# Rezoning Transportation Analysis

Petition Number: #2022-069

Date	Description
09-29-2022	First Review (KP)

Project number: 19016.01 **Sheet:** RZ-1
Date: 2022.12.21
Drawn by: TD
Approved by: TD

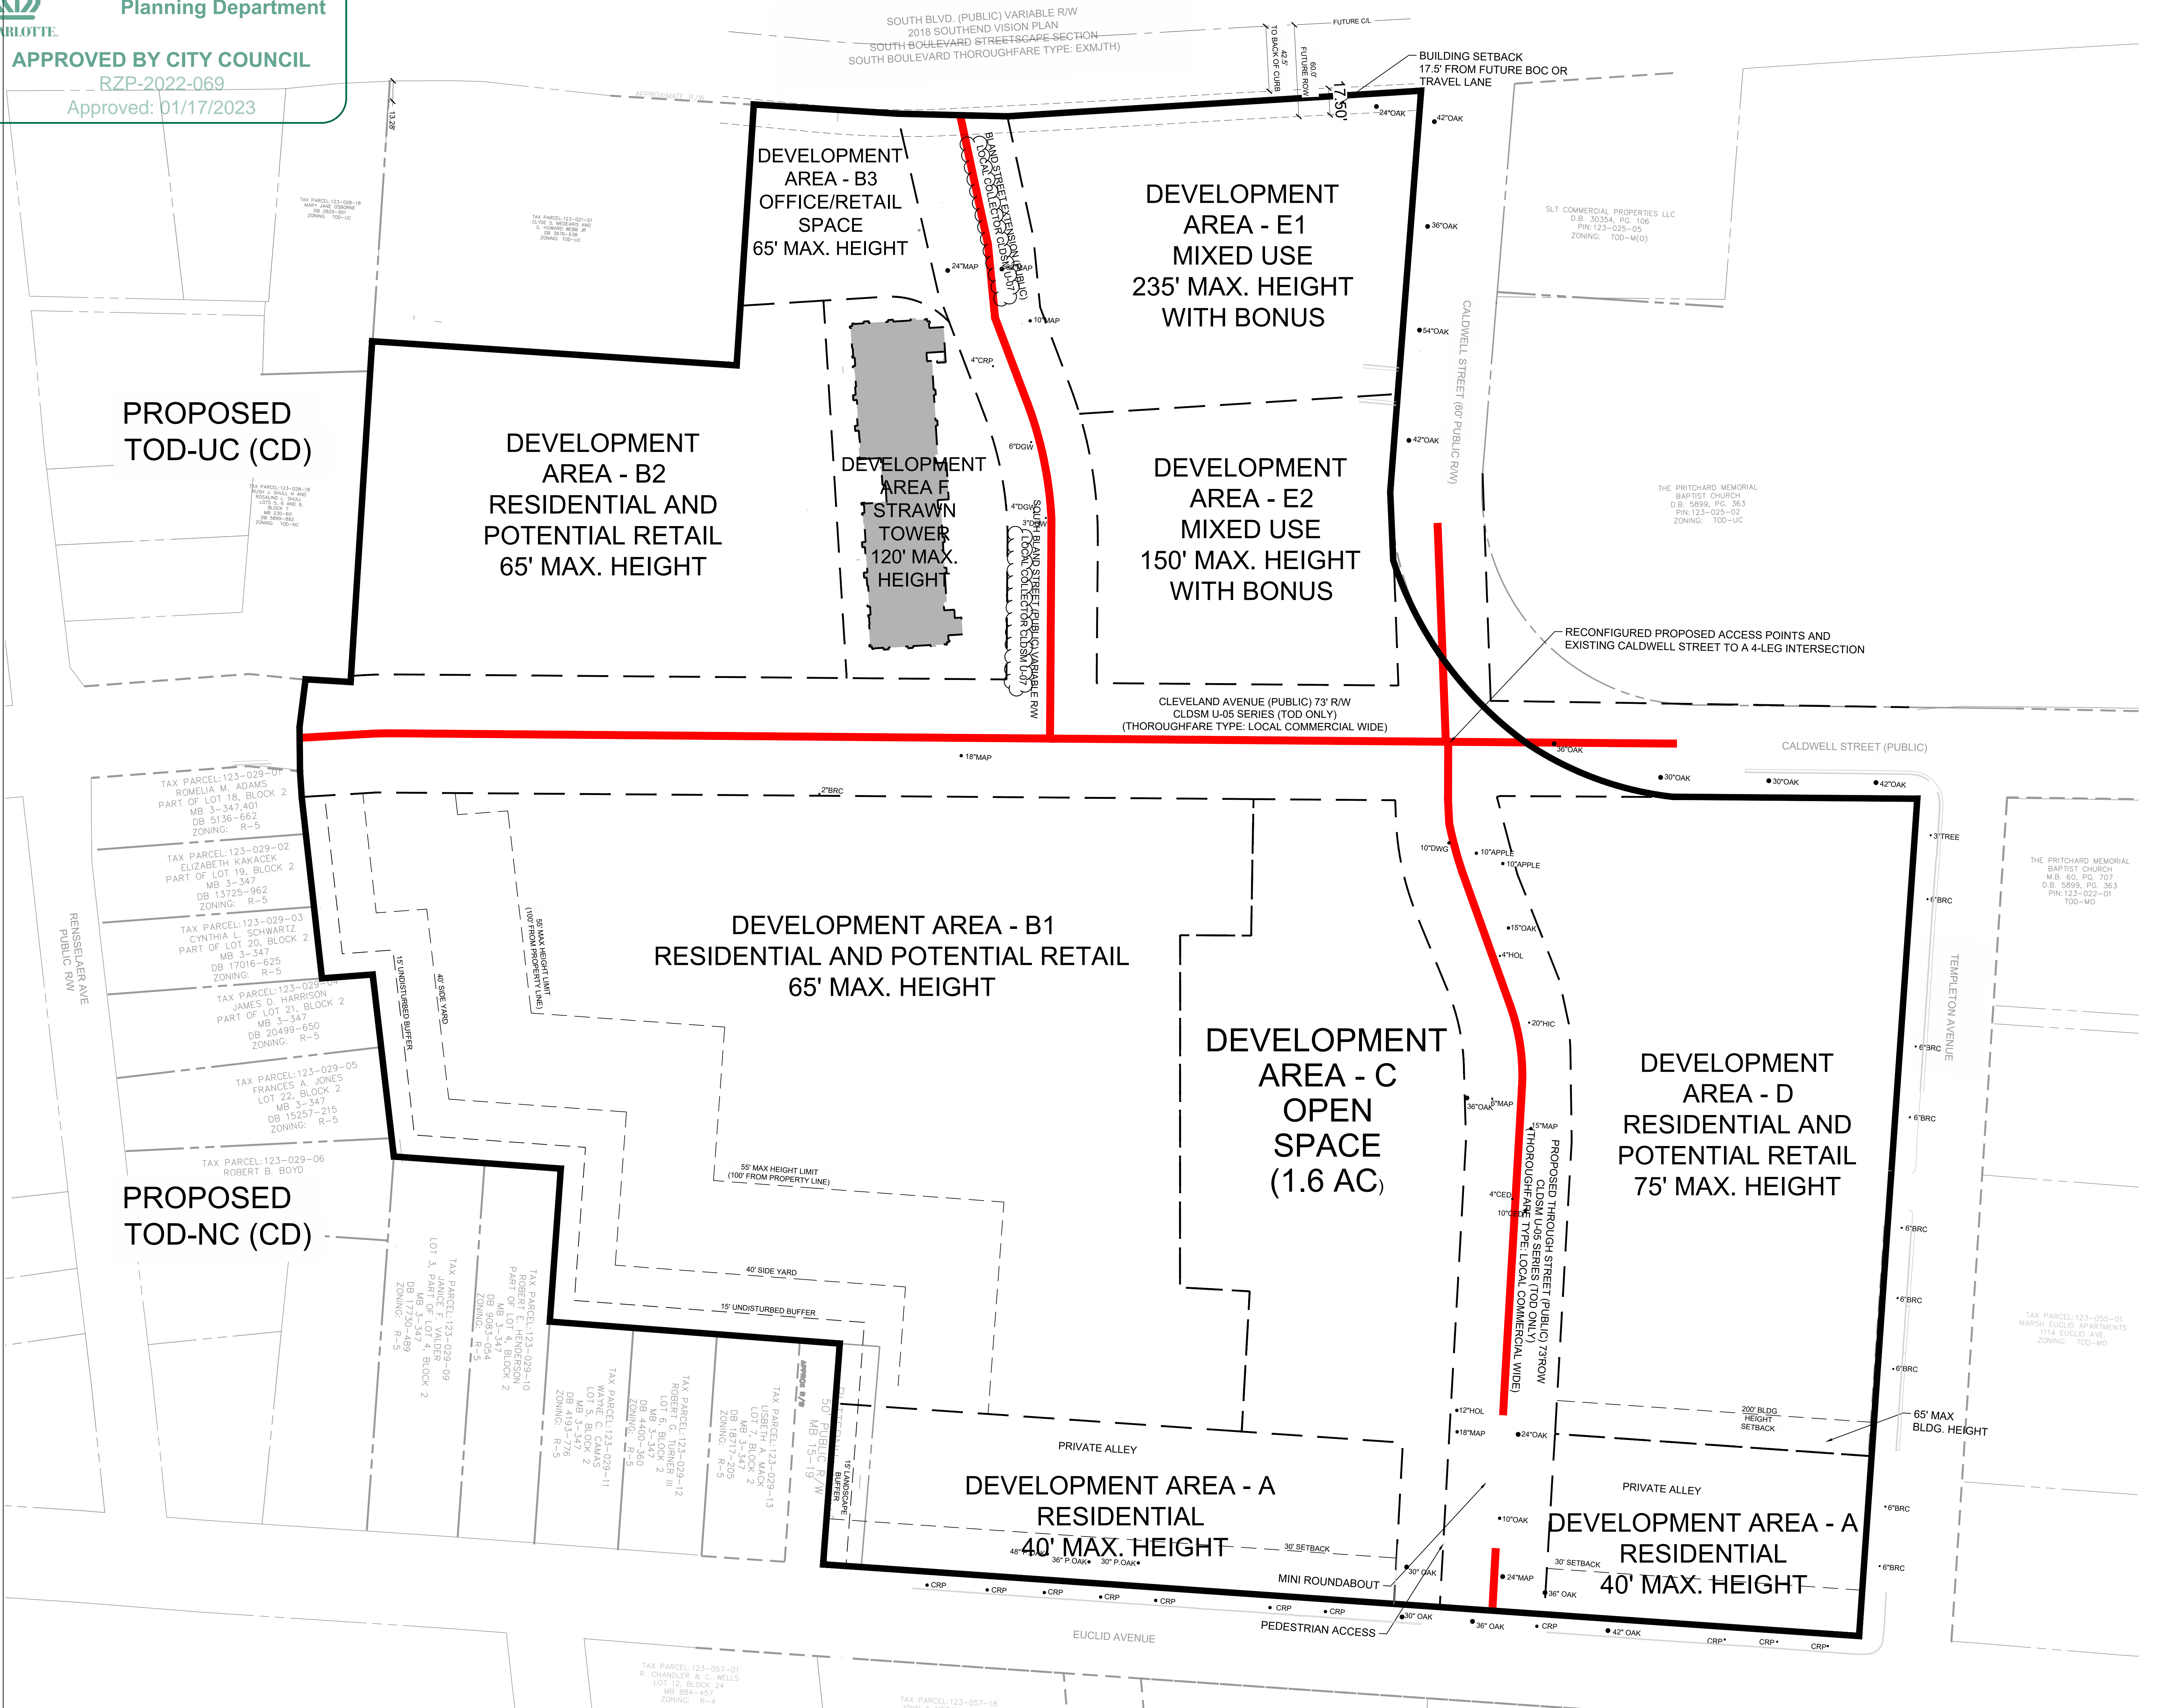
1. **Curb line:** The proposed zoning district has a setback measured from back of the existing or proposed future curb line.
  - a. **South Boulevard:** The location of curb and gutter shall be relocated to 42.5-feet measured from the existing road centerline to back of curb.

Label and dimension the curb and gutter from existing road centerline on the site plan.

3. Revise site plan and conditional note(s) to commit to dedicate 60-feet of right-of-way, along the site's frontage of South Boulevard, from the existing road centerline. The site plan shall label and dimension the right-of-way from the road centerline.

4. Revise the site plan and conditional note(s) to commit to construct an 8-foot planting strip/amenity zone and an 8-foot pedestrian zone, in accordance with the TOD Ordinance, along each public street frontage. The site plan shall label and dimension each item from the back of curb and gutter.

5. Revise the site plan and conditional notes by clearly defining the public and private street network by labeling and dimensioning each proposed street accordingly. For public streets, label the appropriate CLDSM USDG Cross Section each street will be constructed to, and label and dimension the right(s)-of-way, amenity zone(s), and pedestrian zone(s). For private streets, label and dimension the edge of pavement to edge of pavement and the pedestrian infrastructure, if applicable.

6. Revise the conditional notes by removing note 3.e.II.

7. A site plan note(s) specifying dedication and fee simple conveyance of all rights-of-way to the City before the site's first building certificate of occupancy is issued as needed. CDOT requests rights-of-way set at 2' behind back of sidewalk where feasible.
8. Note that the following conditional note revision is a placeholder as the phasing of the roadway and pedestrian improvements/connections will be coordinated during the TIS. The final agreed upon phasing will be appropriately reflected in the final rezoning submittal:  
A site plan note specifying that all transportation improvements will be approved and constructed before the site's first building certificate of occupancy is issued as needed. The petitioner may phase transportation improvements if said improvements and phasing are explicitly described in site plan notes.
